**ONE EARTH SOLAR FARM DEVELOPMENT CONSENT ORDER EN010159 – THE
EXAMINING AUTHORITY’S WRITTEN QUESTIONS AND REQUESTS FOR INFORMATION
ExQ1**

I write in response to the Examining Authority’s (ExA’s) written questions and requests for information (ExQ1) issued on 7th August and to provide the response of Nottinghamshire County Council (NCC) (Interested Party FD2E7A44C) in relation to those questions which are addressed directly to NCC or the Councils, where deemed relevant to the responsibilities of the County Council.

Figure 4.1: Barred Route Plan

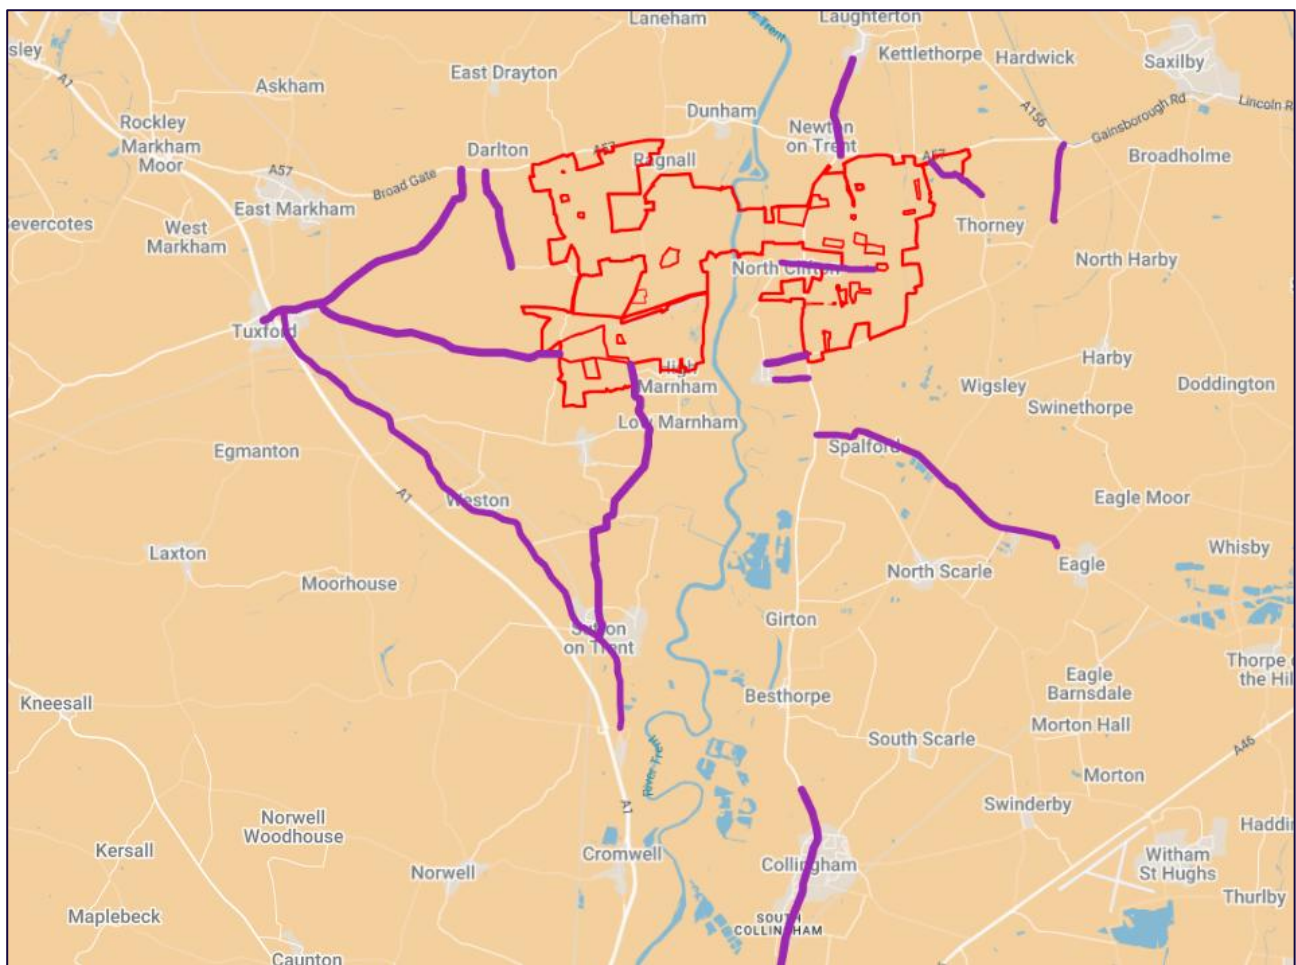
18. Transportation and Traffic			
Q18.02	NCC	Crabtree Lane and Moor Lane Are NCC satisfied with the passing places proposed by the Applicant in the revised oCTMP at Deadline 1?	The Highway Authority do not think that any references to passing places are included in the oCTMP. The only reference appears to be in the Transport Assessment in paragraph A.12.5.18 which identifies an existing passing place on Crabtree Lane. The Highway Authority do not consider that this is acceptable, and no consideration has been given to Moor Lane. Our response given in the LIR still therefore applies in respect to Crabtree Lane and Moor Lane. As per our response to Q18.0.8, the Highway Authority has subsequently met with the applicant's transport consultant and identified suitable standards for them to consider with regards to the provision of passing bays. Further information has not been provided as yet so in conclusion, we are not satisfied with the passing places currently proposed by the Applicant.
